## **Application by Anglian Water Services Limited for an Order Granting Development Consent for the Cambridge Waste Water Treatment Plant Relocation project**

### **The Examining Authority's third written questions and requests for information (ExQ3)**

**Issued on 21 March 2024**

- Scheme Order Limits
- Land ownership data
- Site 3
- Waterbeach corridor

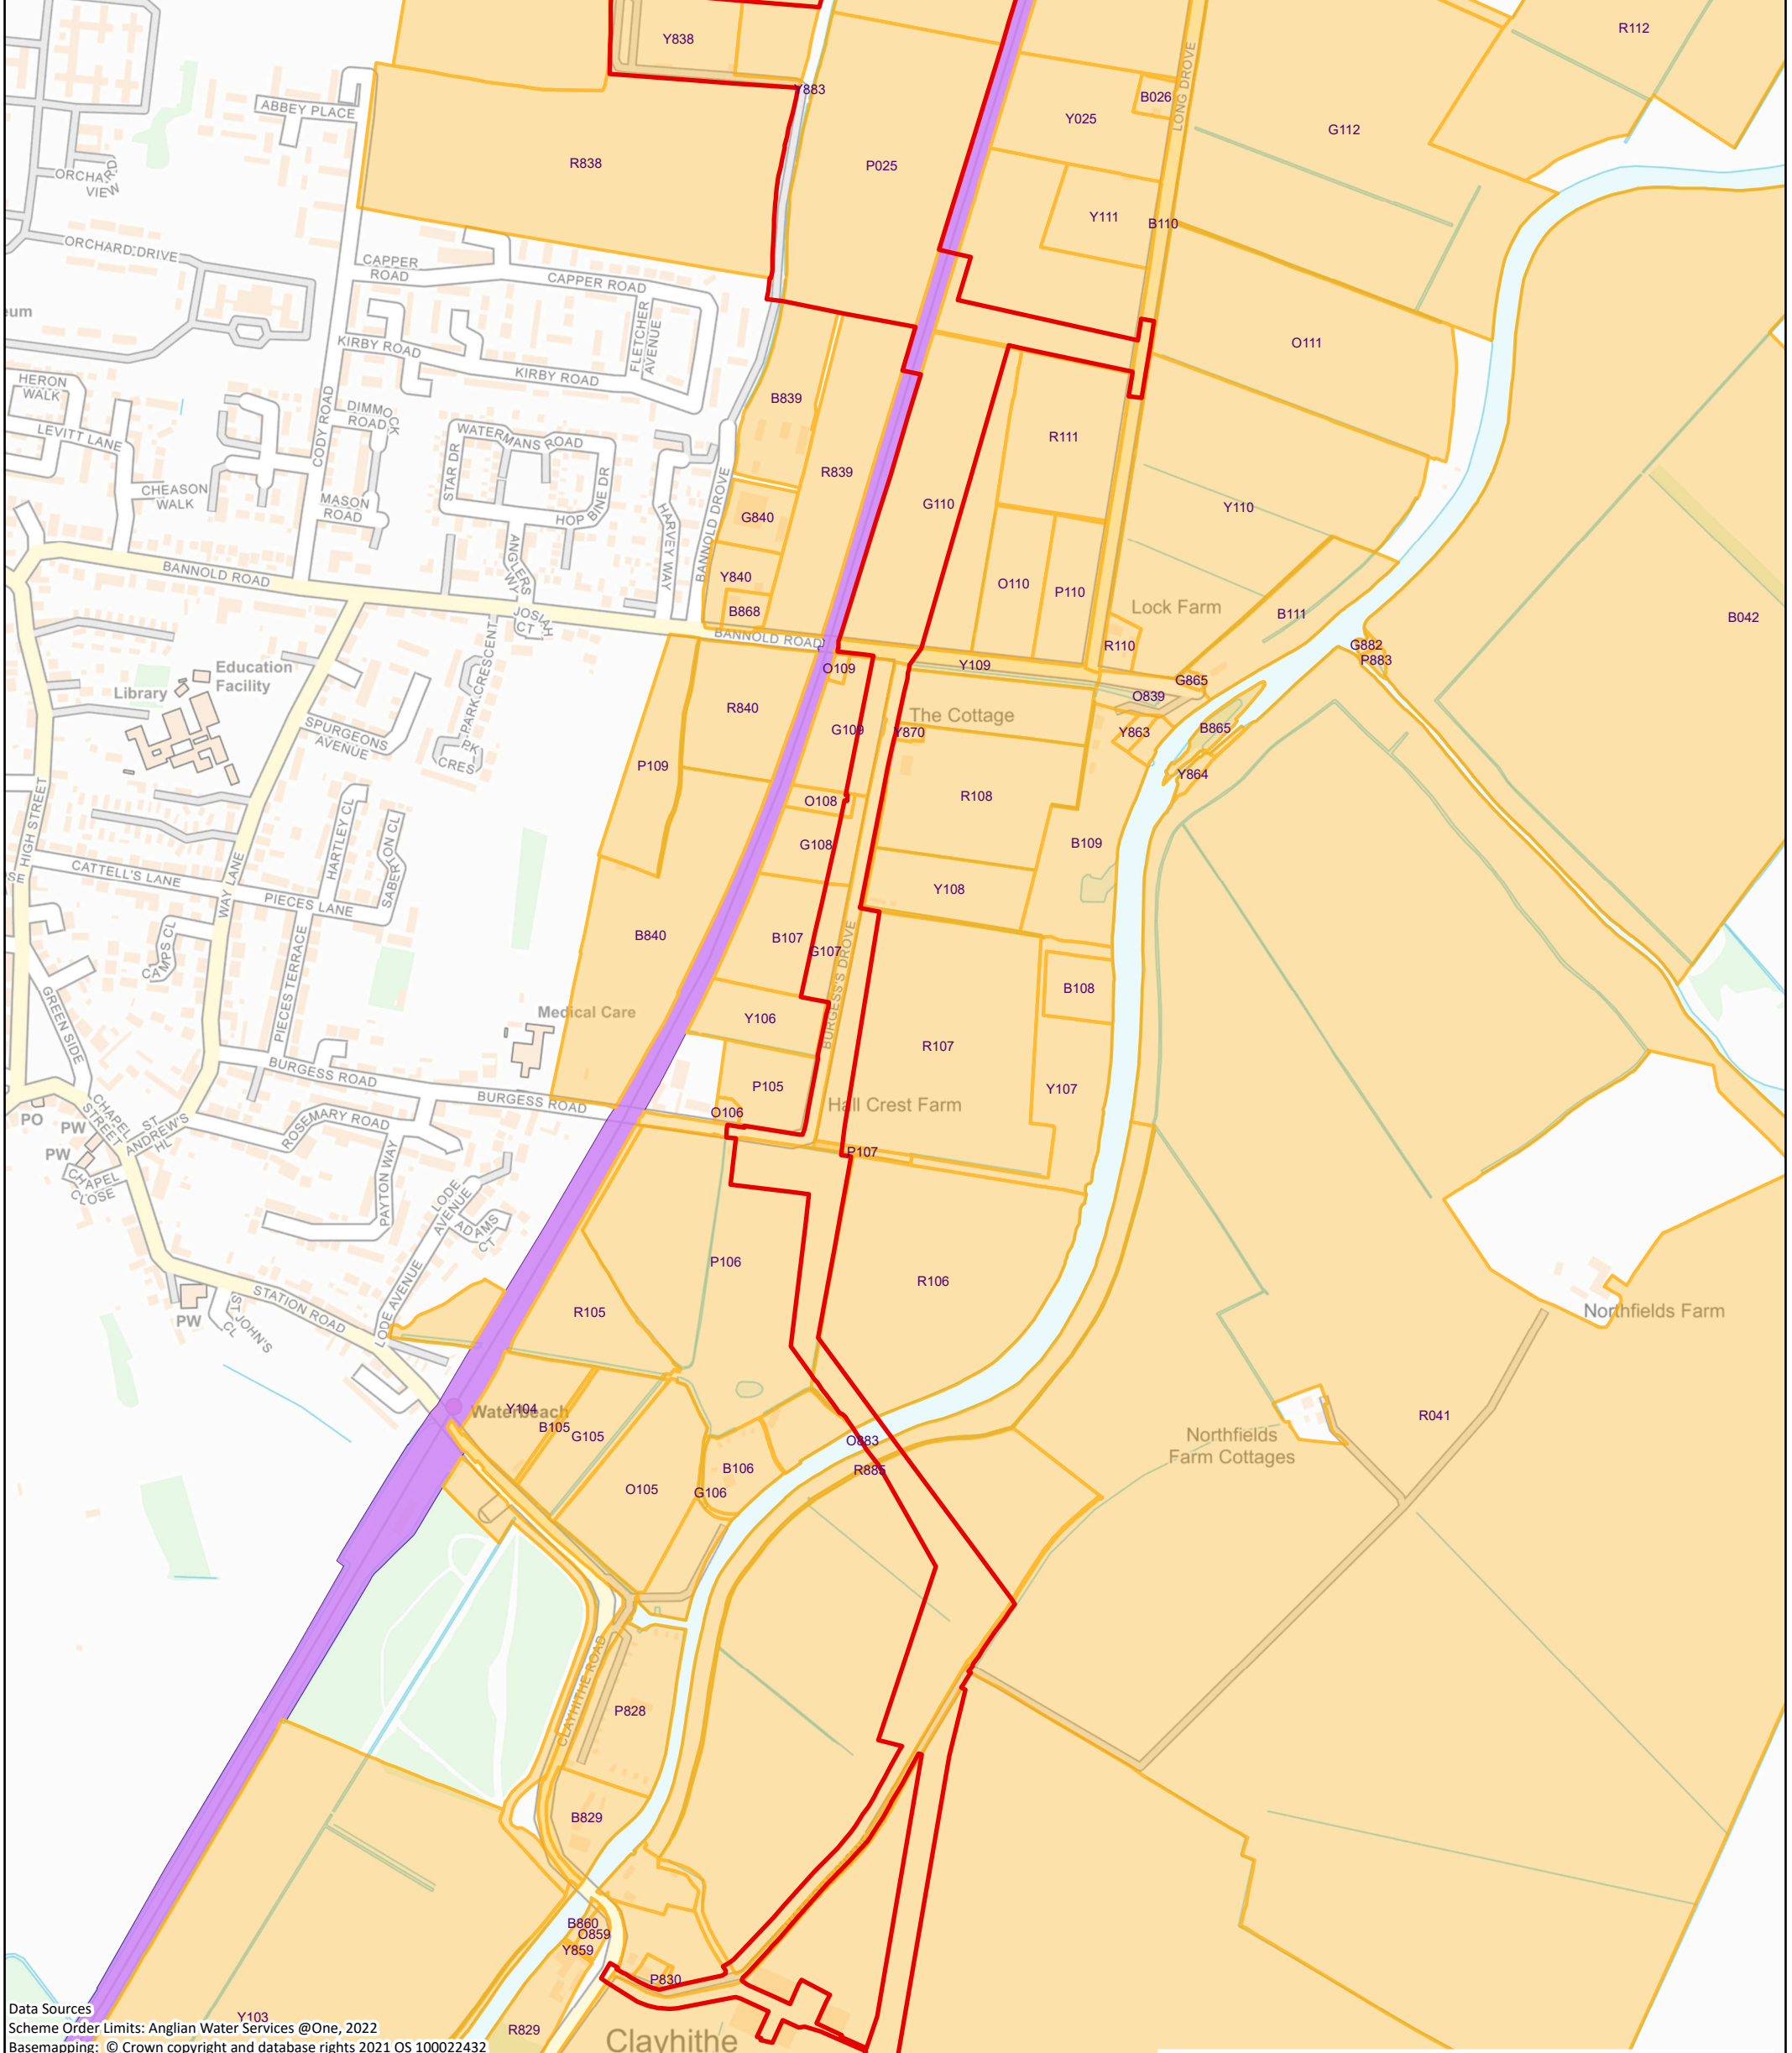
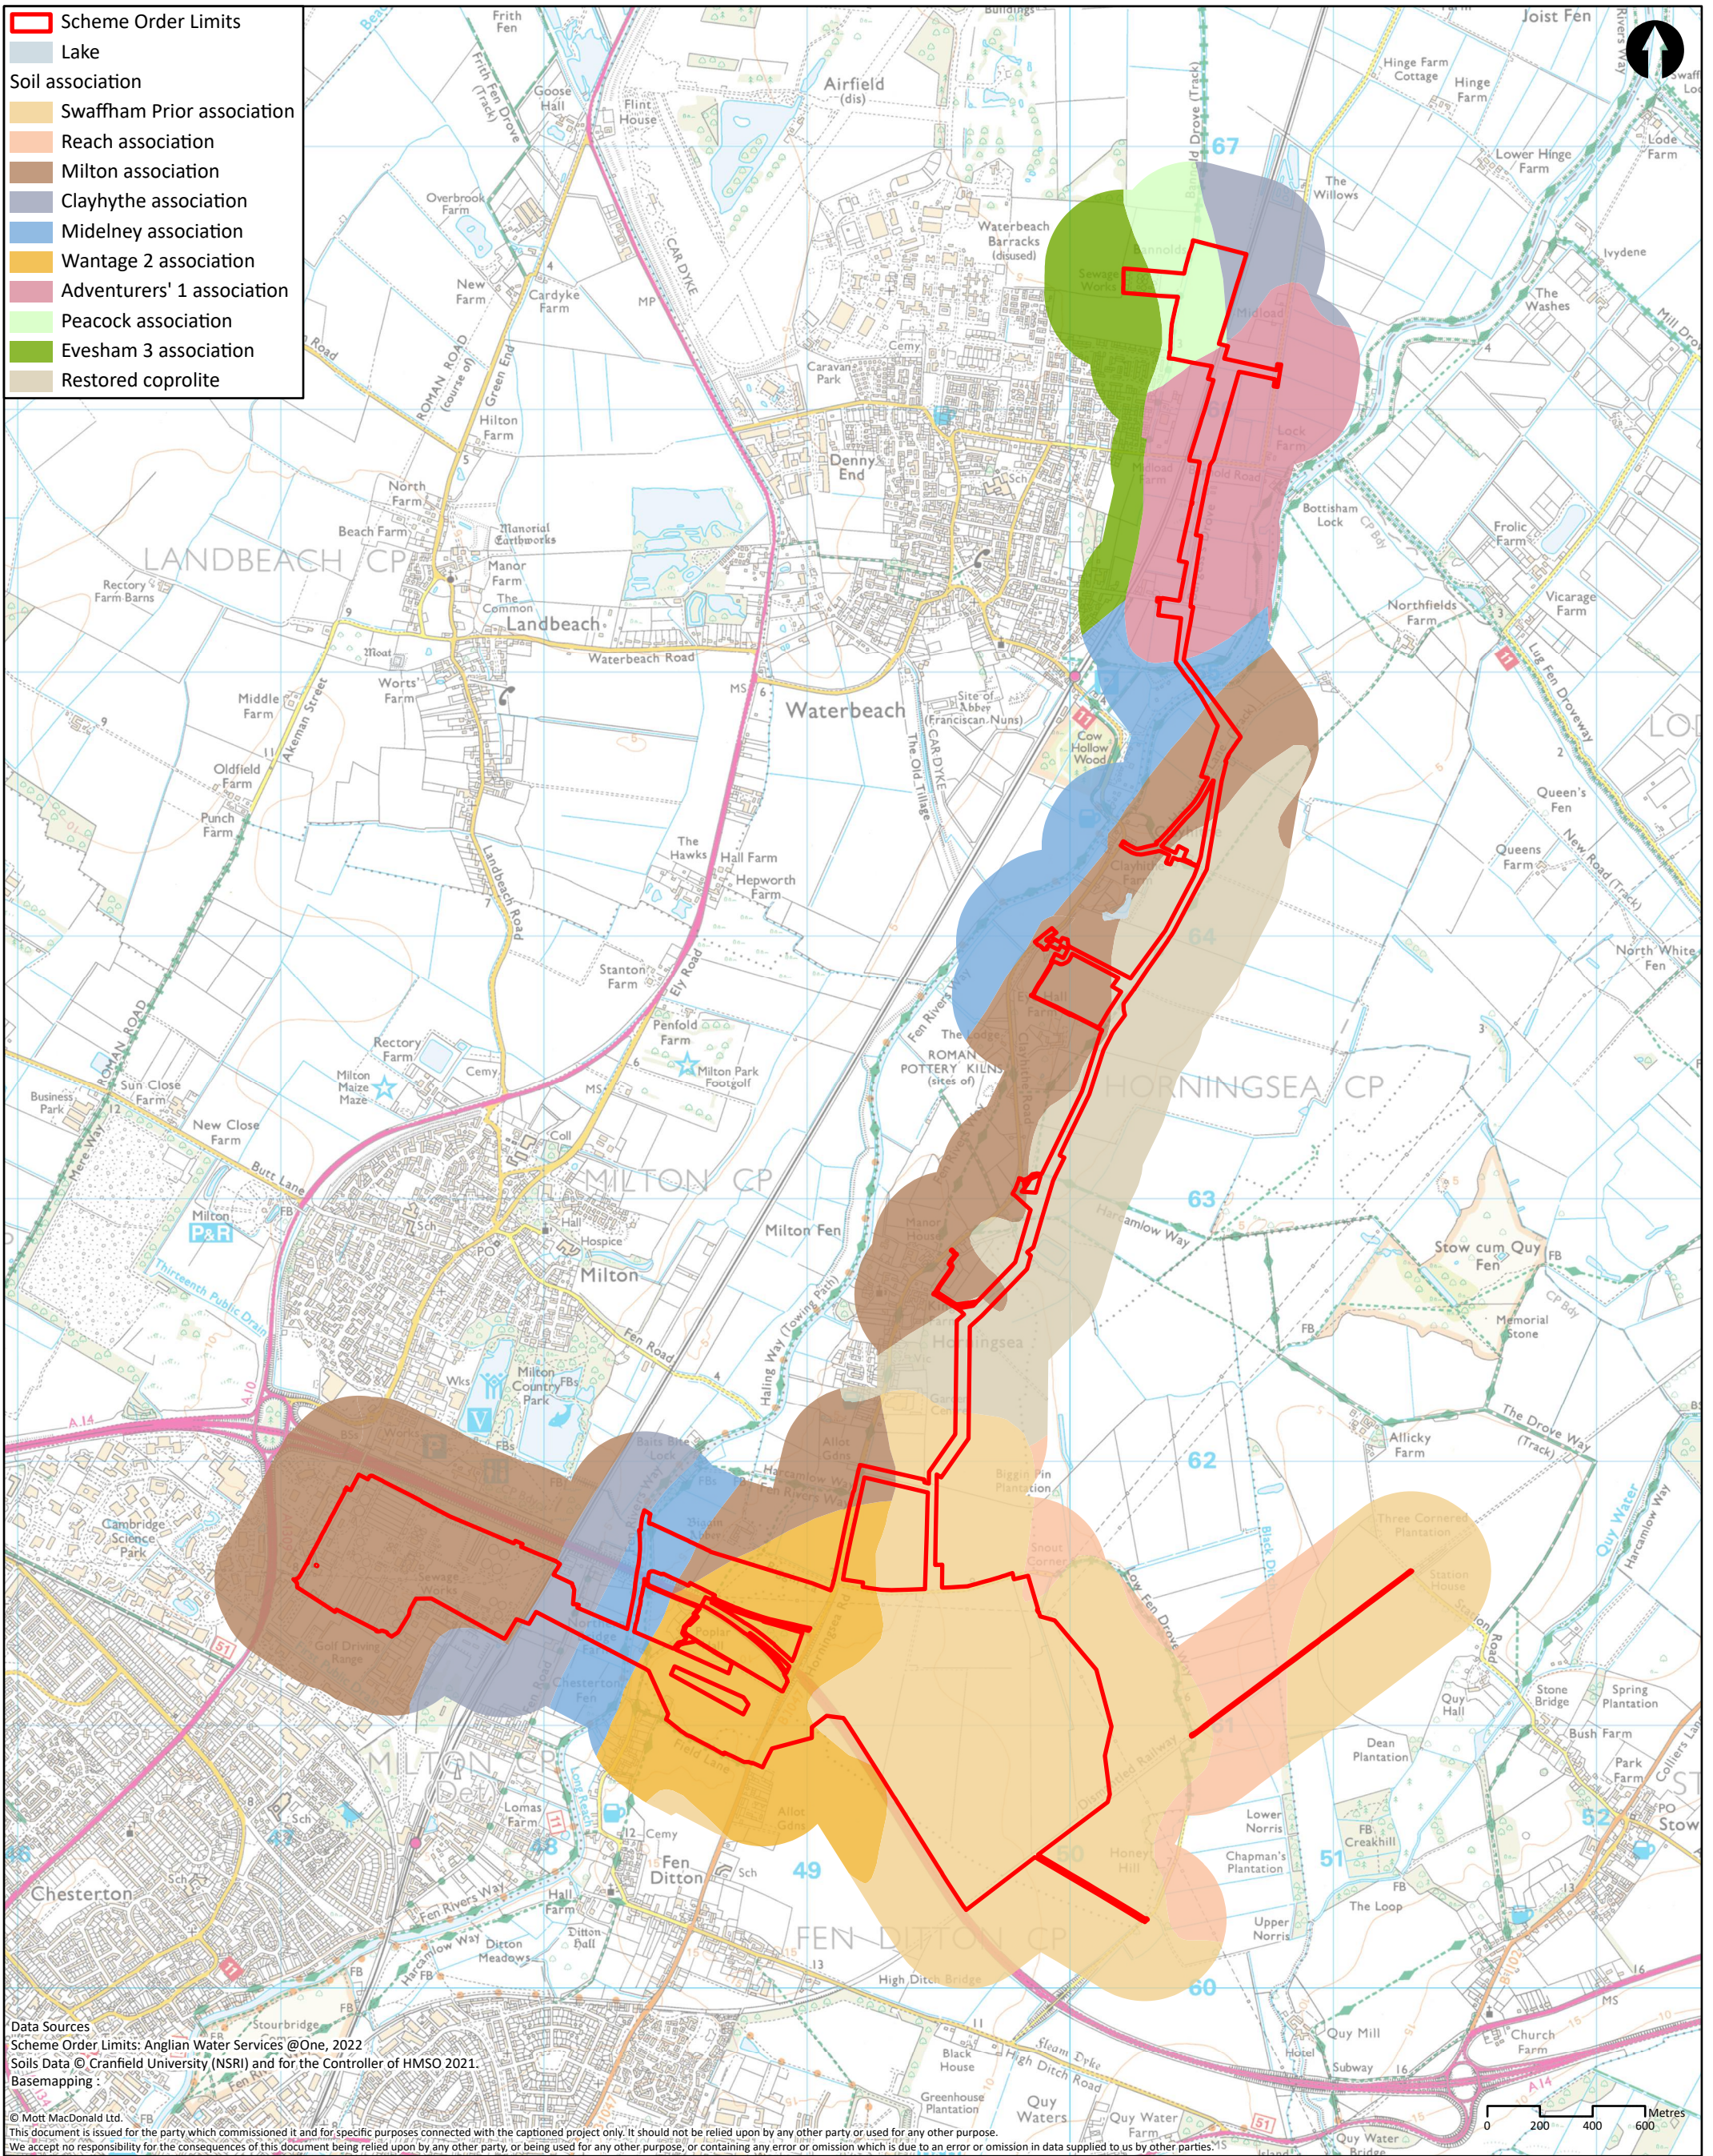
3.1	Applicant	<b>Farm holdings clarification</b> It is unclear from ES Figures 6.11 to 6.14 [AS-049] which farm holdings Plots 036b, 036c, 038c, 042a and 046b relate to. Please clarify / rectify.
<b>4. Air quality</b>		
No further questions at this stage.		
<b>5. Biodiversity</b>
